Our Ref: FG/115/17/PL
Your Ref:

Town & Country Planning Act 1990 (as amended)
Town and Country Planning (Development Management Procedure) (England) Order 2015
Application for Planning Permission

Development 4 No. bungalows
Location 44 Ferringham Lane Ferring

OS (site location plan)

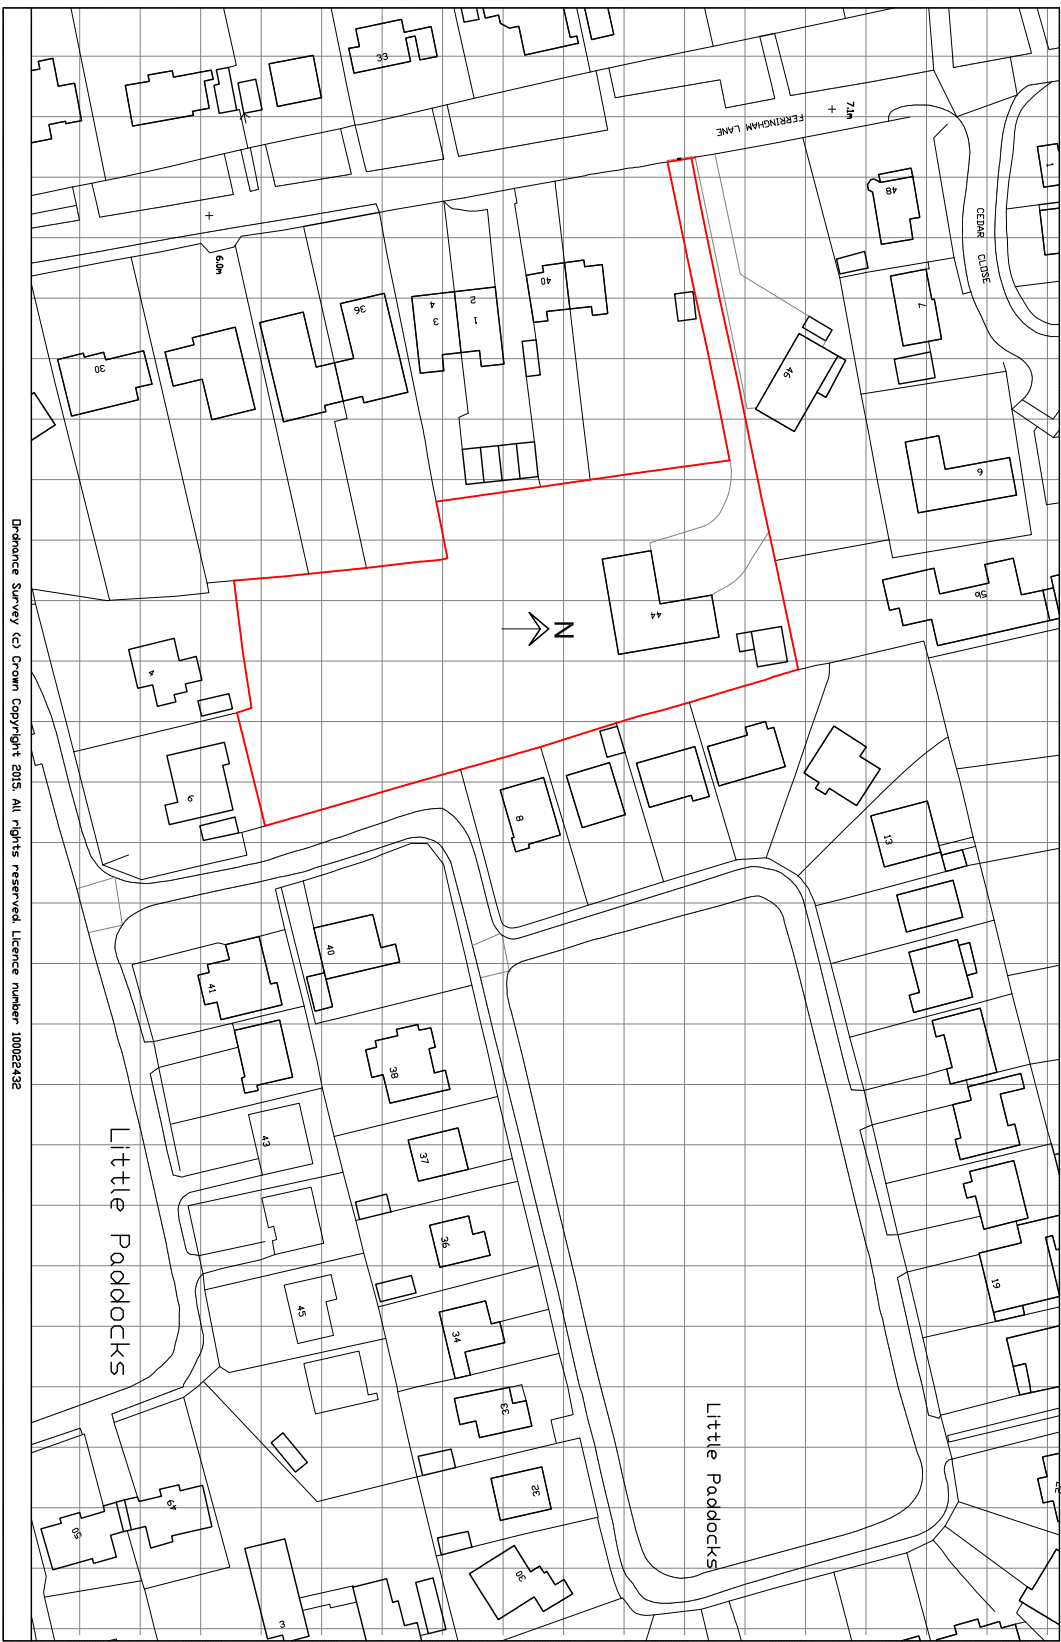
On the site location plan please provide a North point.

Roof plans

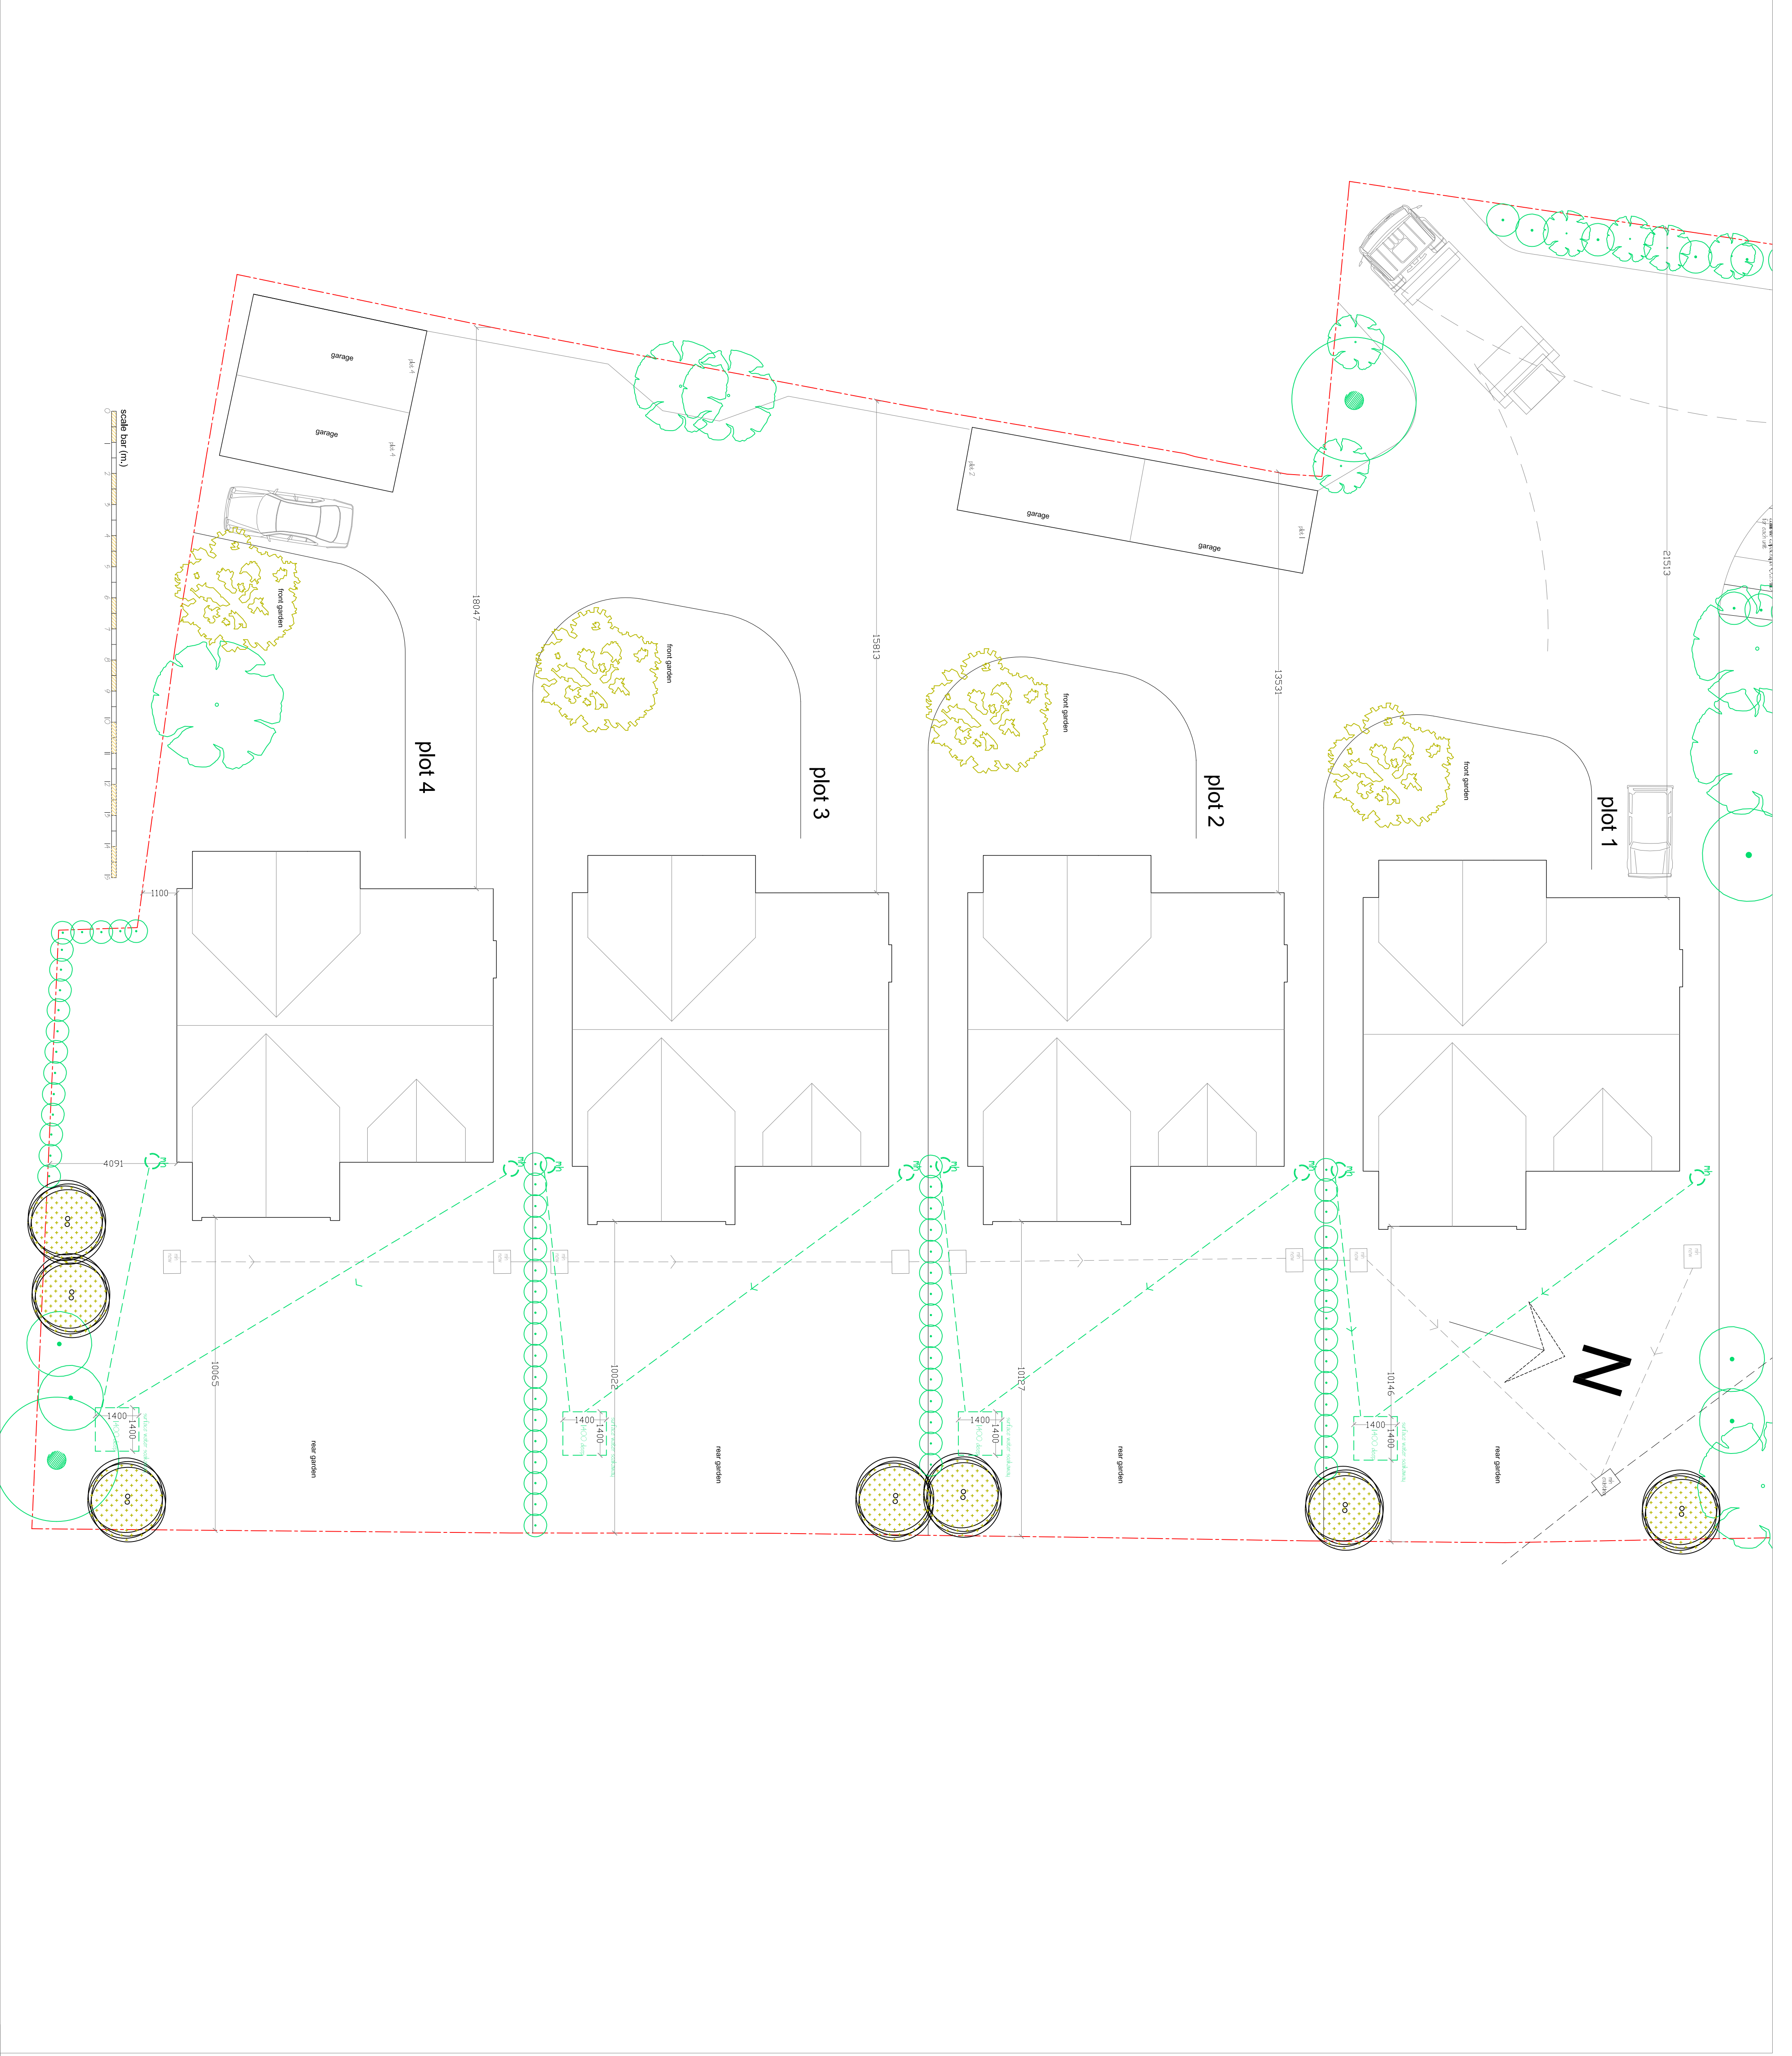
On the site layout block plan please provide a North point and provide measurements from the proposals to the site boundaries.
